**CHARLOTTE - MECKLENBURG**  
**PLANNING COMMISSION**

**SUBJECT:** Administrative Approval for Petition No. 97-43 by William Putnam Ross, r. Marion Ross, Jr.,  
Robbie G. Ross.

**Technical Data Sheet**  
Petition # 97-43

Technical Data Sheet
Petition # 97-43

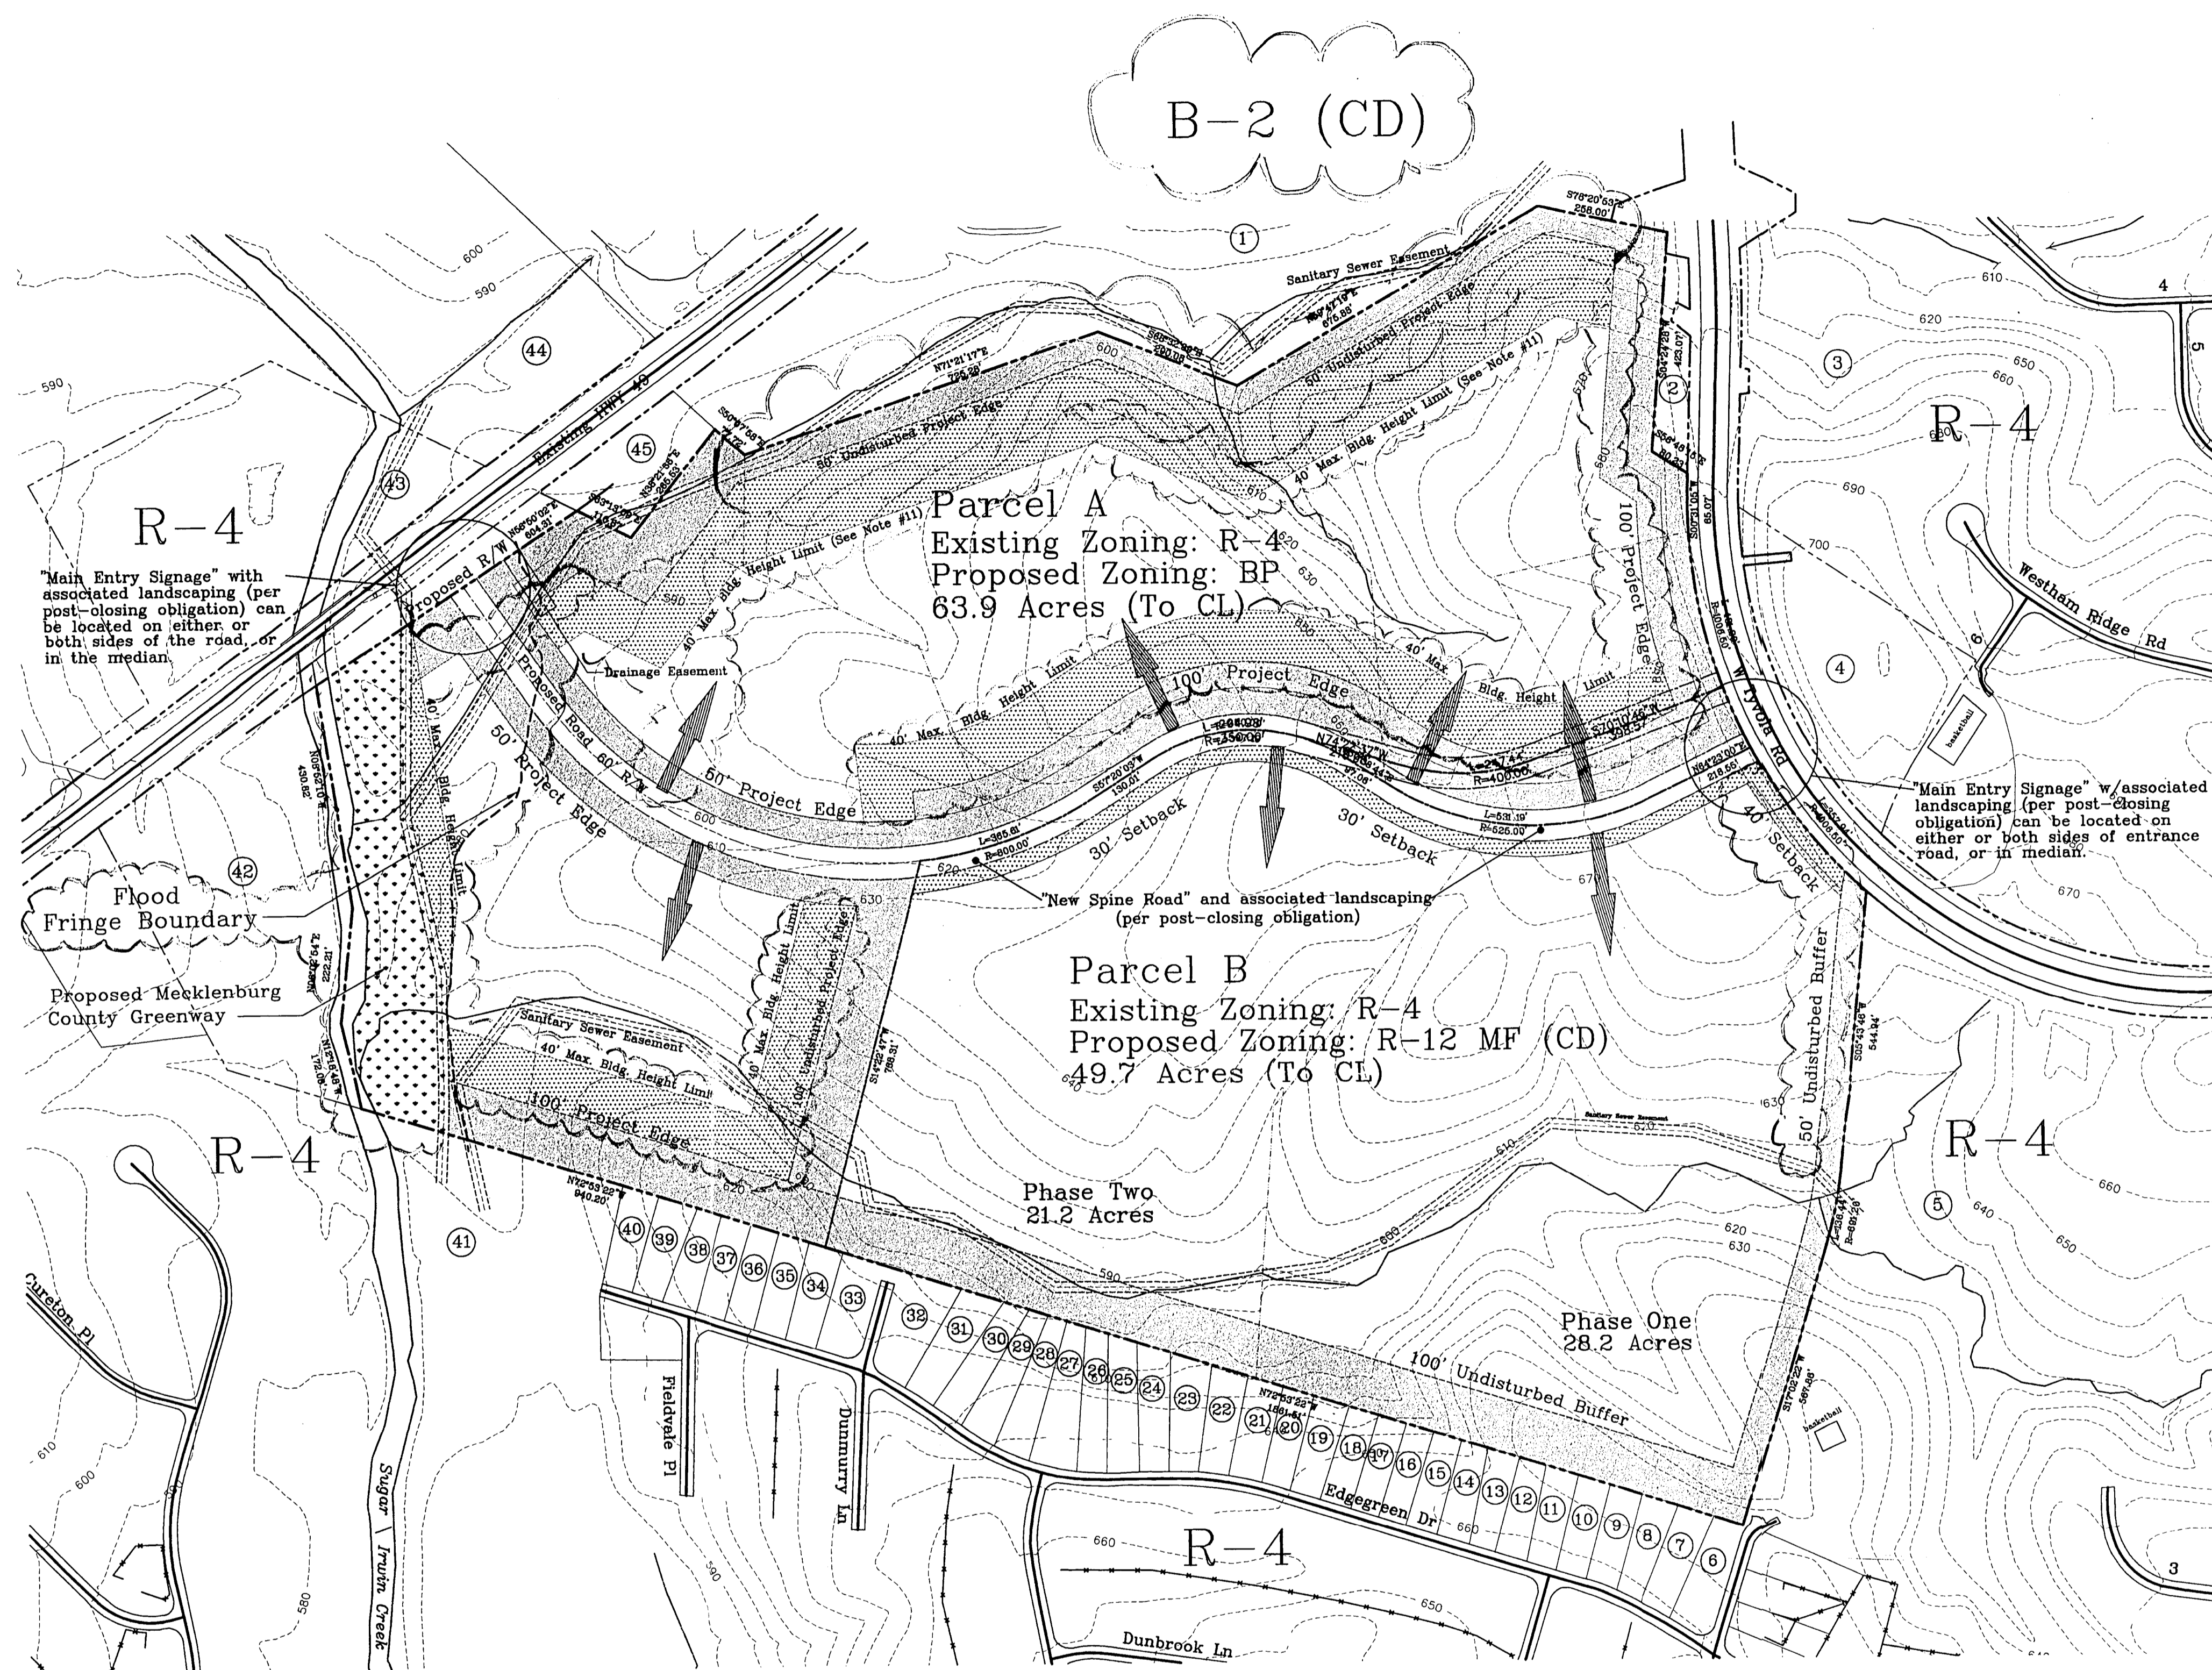
Attached is the revised technical data sheet for the above petition. The plan has been revised to allow dedication of the greenway prior to the issuance of a certificate of occupancy for the first building adjoining this greenway and to reduce the project edge along the northern property line to 50-feet. Since these changes do not alter the intent of the development and meet the requirements of the Charlotte Zoning Ordinance Section 6.206(2) Alterations to Approval for minor changes, I am administratively approving this plan. Please use this plan when evaluating requests for building permits and certificates of occupancy.
